From: Paul Cann
Sent: 08 May 2017 16:32
To: Planning.Responses
Subject: RE: Planning Consultation on: R/91/17/PL

Engineers comments in respect to surface water drainage:

APPLICATION R/91/17/PL

Site Address: The Spires Springfield Close East Preston BN16 2SZ

JOB NO. 1438 DRAWING NO 01 © 6th MARCH 2017

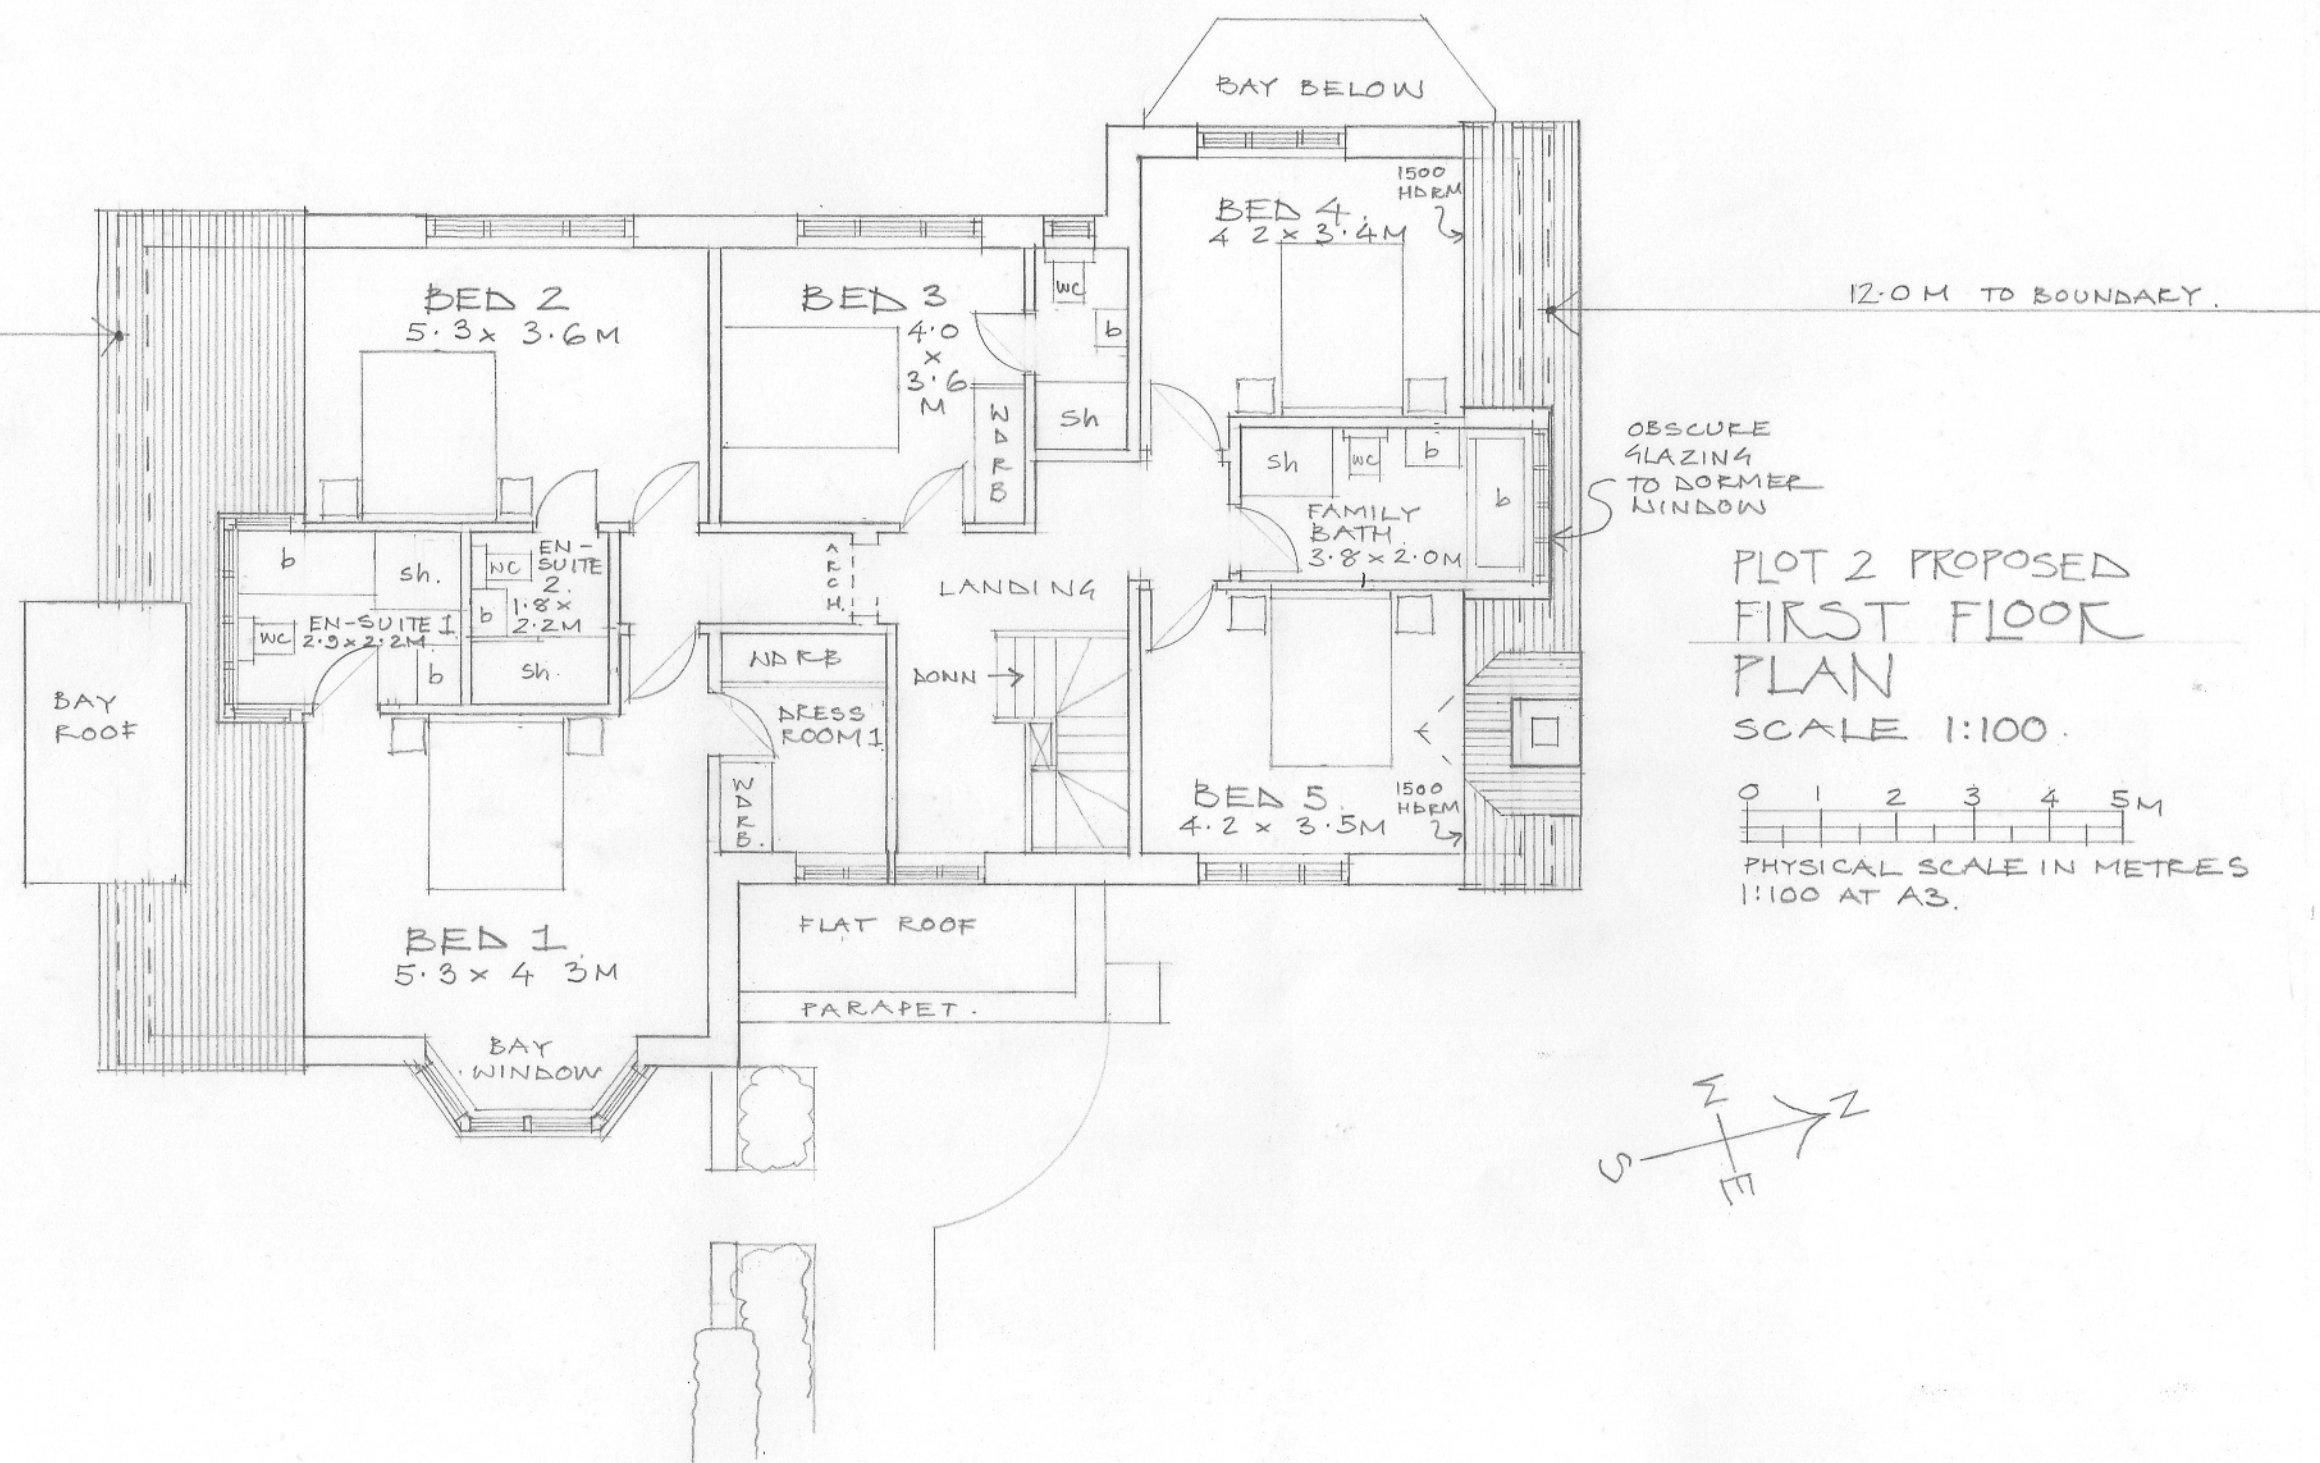
Informative; There is a possibly a highway drain located within the verge on the southern boundary. This may be affected by the proposed new access road and hence may require concrete protection. It would be wise to also verify its condition.
